Office of
Environment
& Heritage

Date: 9 August 2017
Your reference: SSD 3846
Our reference: DOC17/400692
Contact: Calvin Houlison
4224 4179

RE: West Culburra Mixed Use Concept Plan Supplementary Response To Submissions (SSD 3846)

WEST CULBURRA MIXED USE CONCEPT PLAN

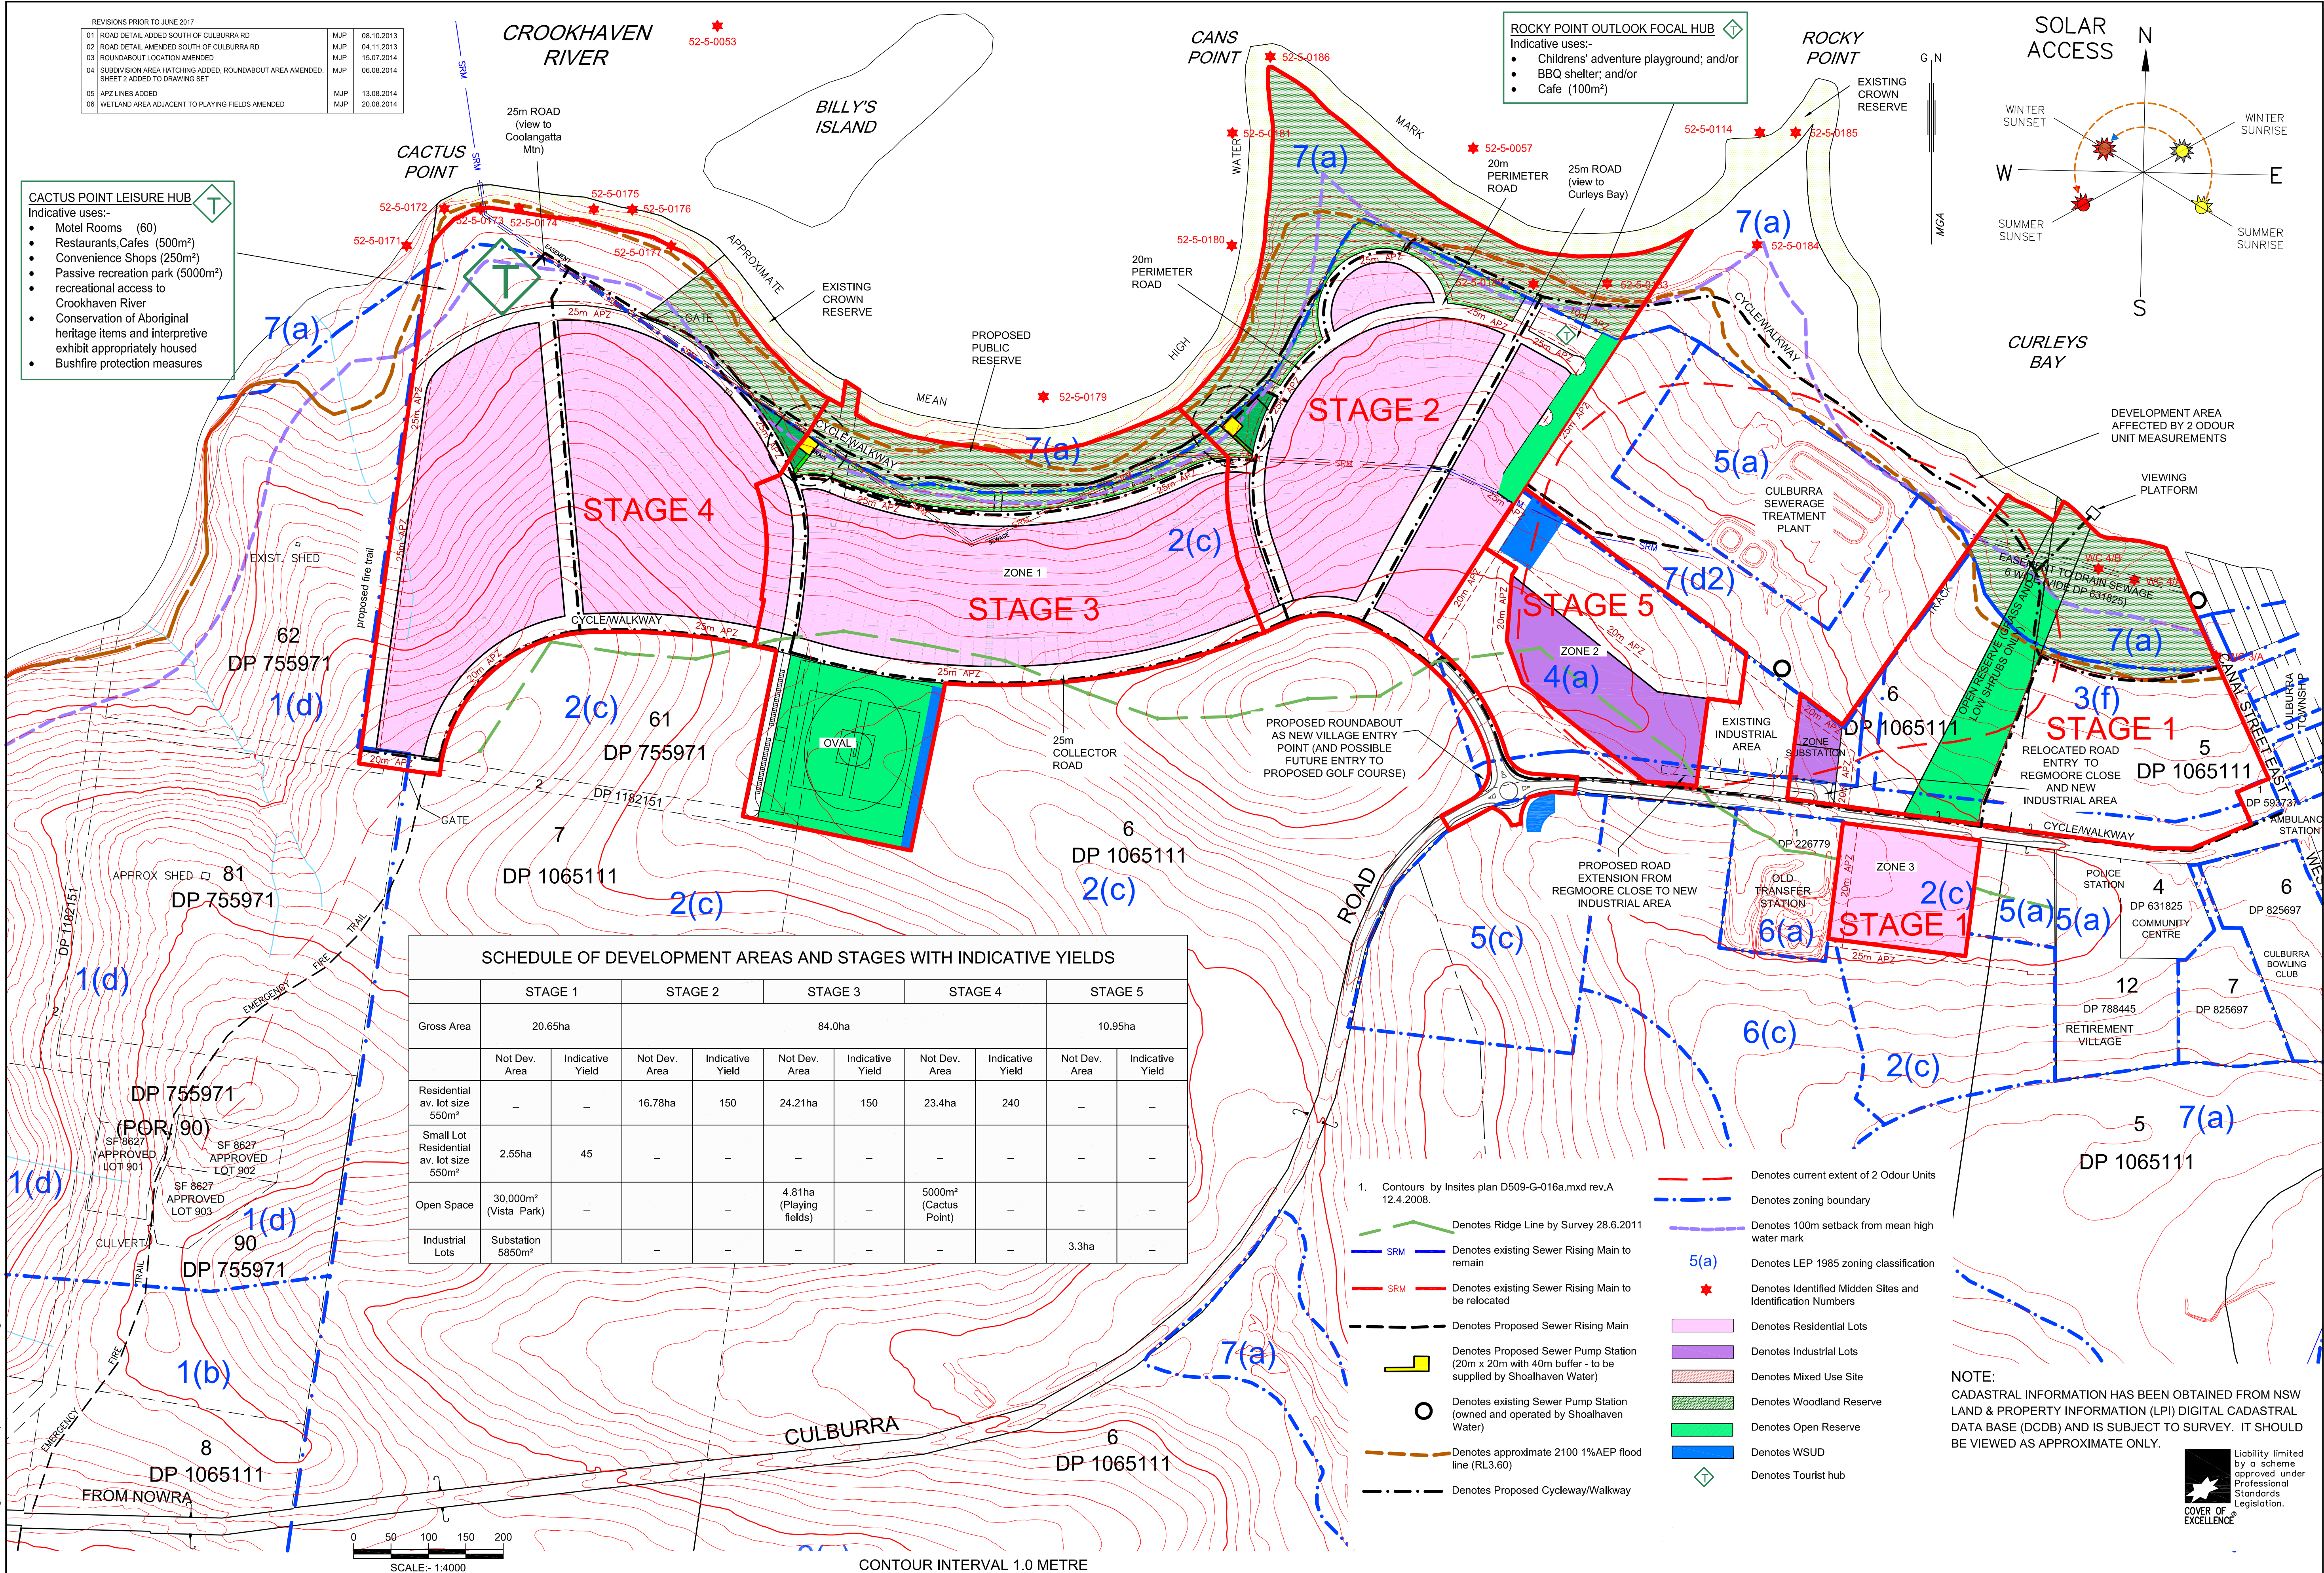
- Sites which appear within the Lake's catchment include the proposed public oval adjacent to the southern perimeter road at Site D and the south-western corner of Site C encompassing proposed industrial land. The majority of Site B, which is proposed for residential use, is within the Lake's

catchment (the enlargement of this area since 2014 documents is not supported). There is also a small area of residential zoned land within the southern portion of Site D that appears to be within the Lake's catchment.

- We recognise the justification for locating the oval within the catchment, which appears capable of being drained by gravity back to the Crookhaven catchment. However, the proponent's justification for Site B and Site C is premised upon an administrative land use zoning legacy (established in 1985) rather than a contemporary scientific appreciation of environmental sensitivities (established two decades later and continuing to evolve).
